# CITY OF ALBUQUERQUE

**Re: American Home Furniture  
2100 Carlisle Blvd NE, Suite B  
Request for Certificate of Occupancy- 30 Day Temp  
Transportation Development Final Inspection**  
Plan Date: Stamp 6-29-21, AA 12-4-23 (H17D097C)  
Certification dated 1-28-24

**SITE PLAN FOR BUILDING PERMIT**

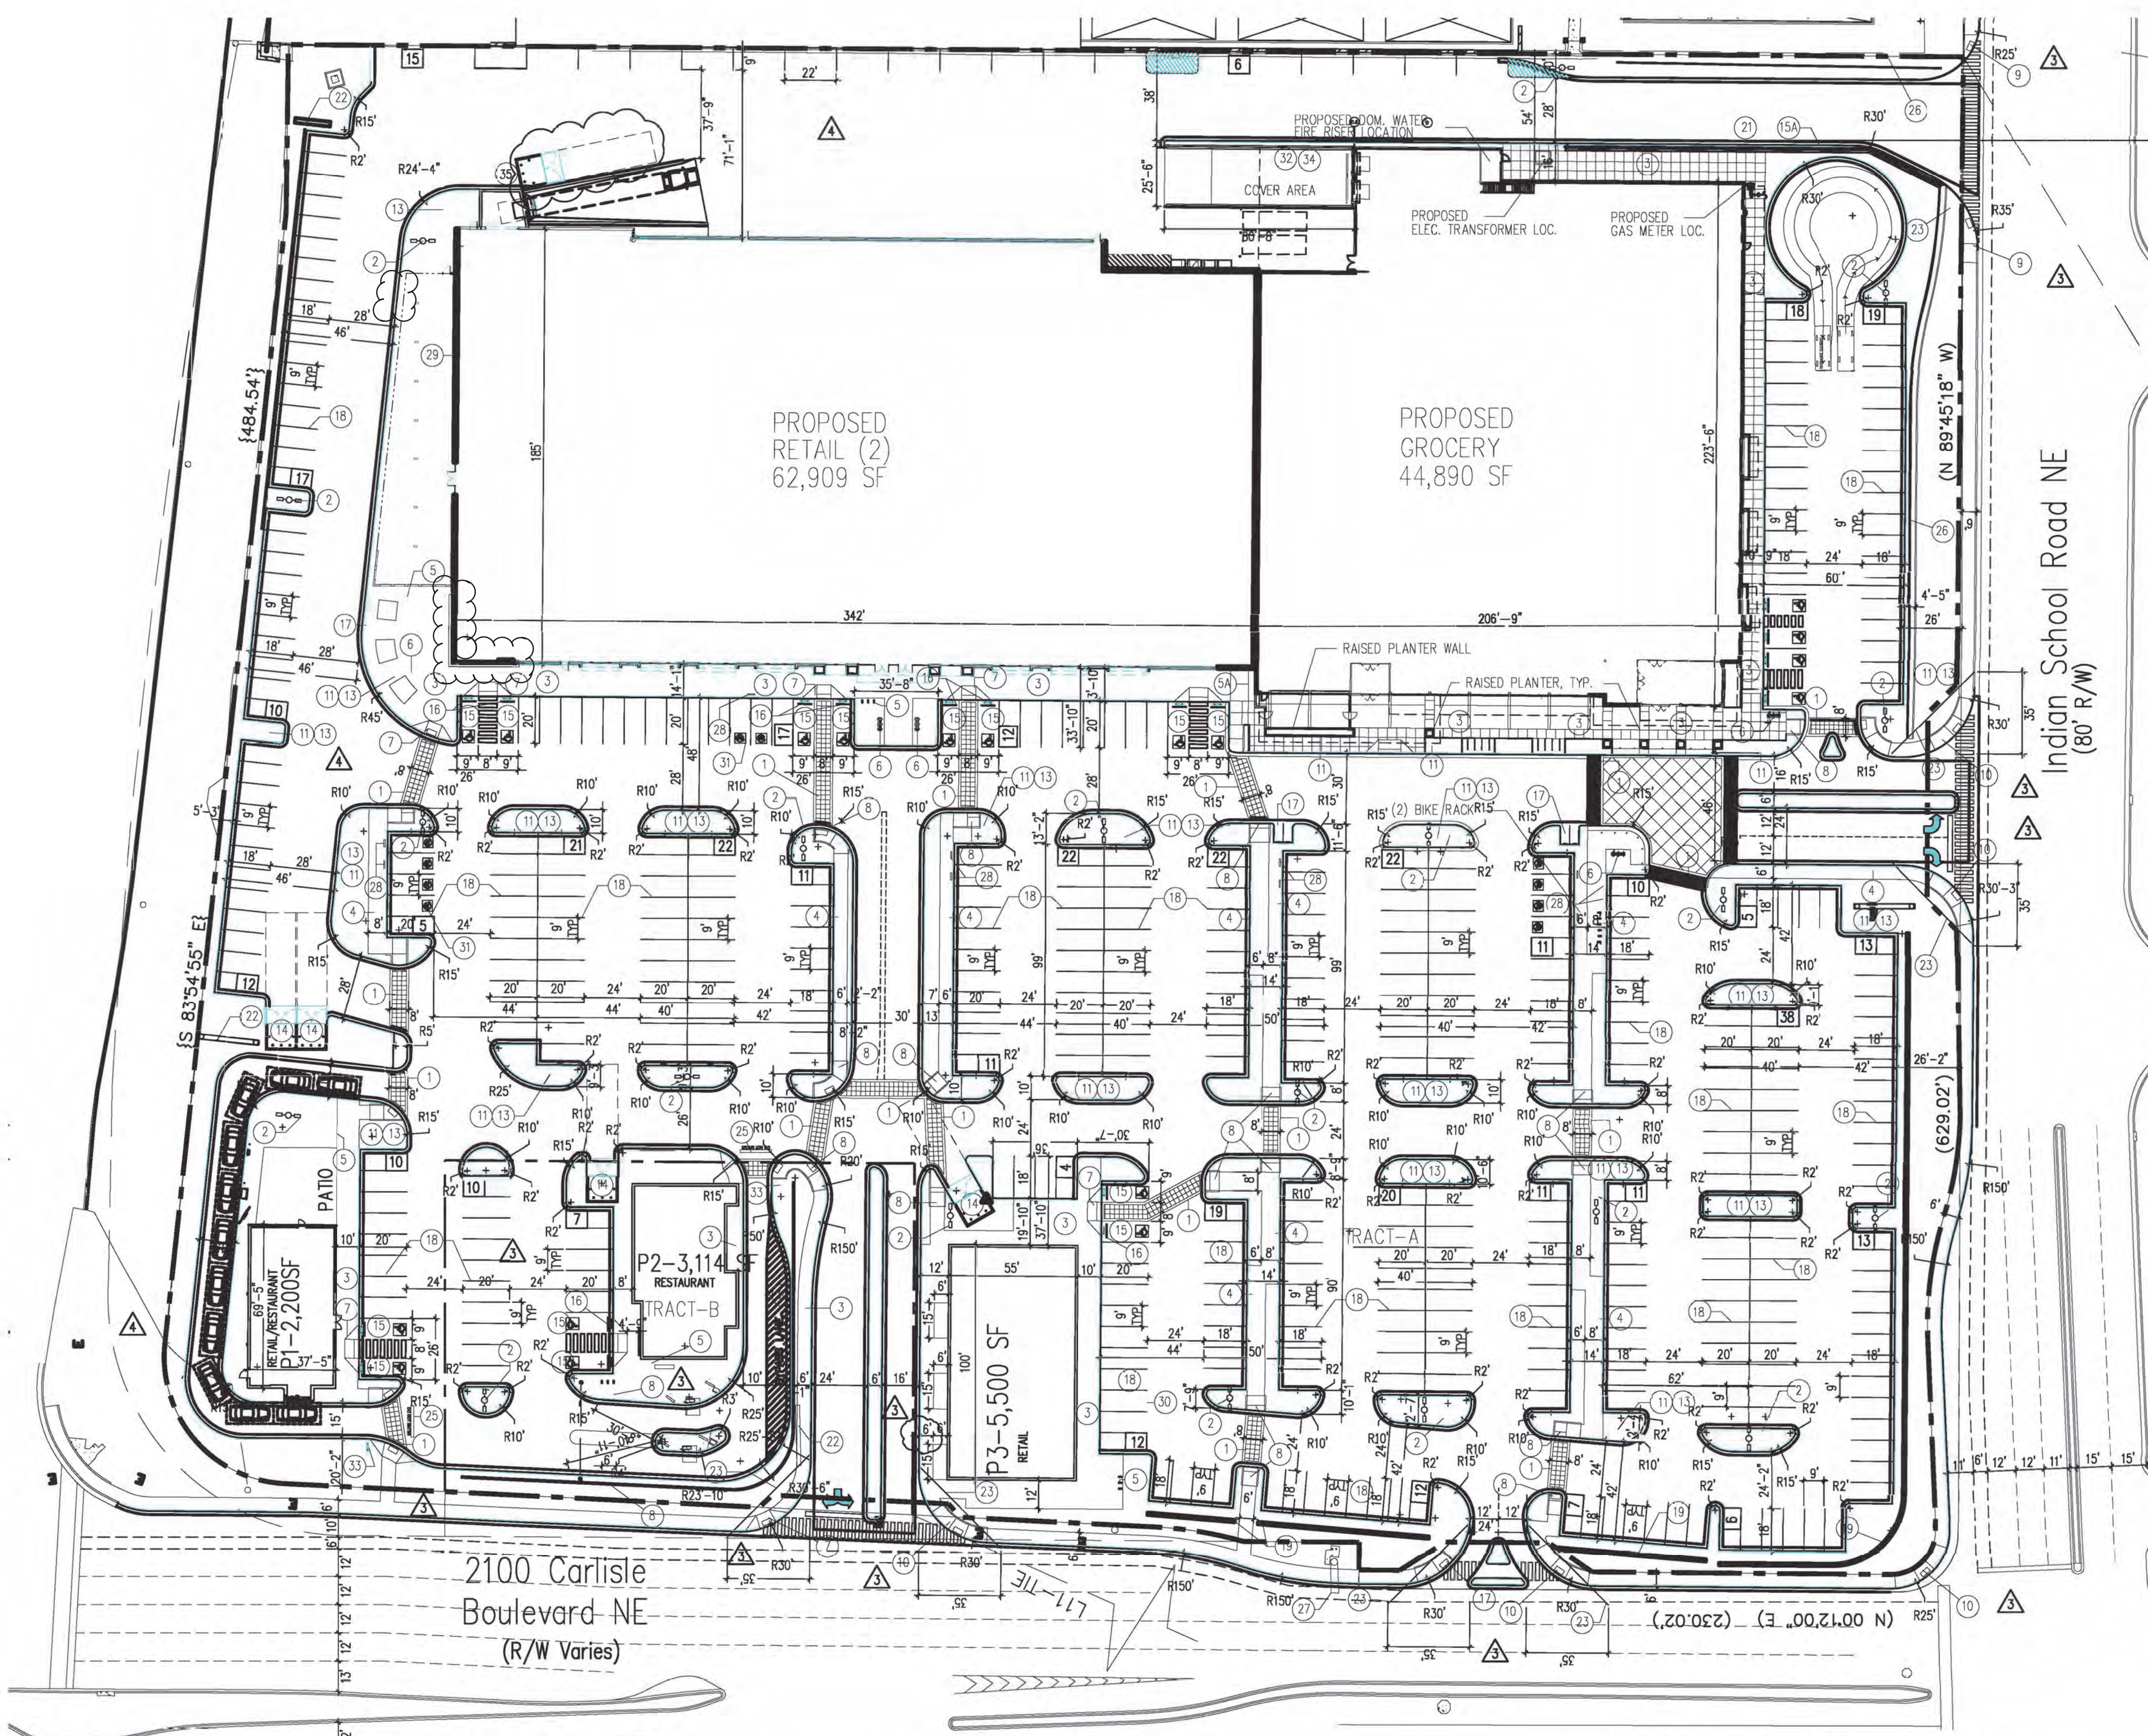
1. Construct 6 bicycle parking spaces.
2. Add truncated domes to the ramps for the pedestrian pathway from Carlisle Blvd.
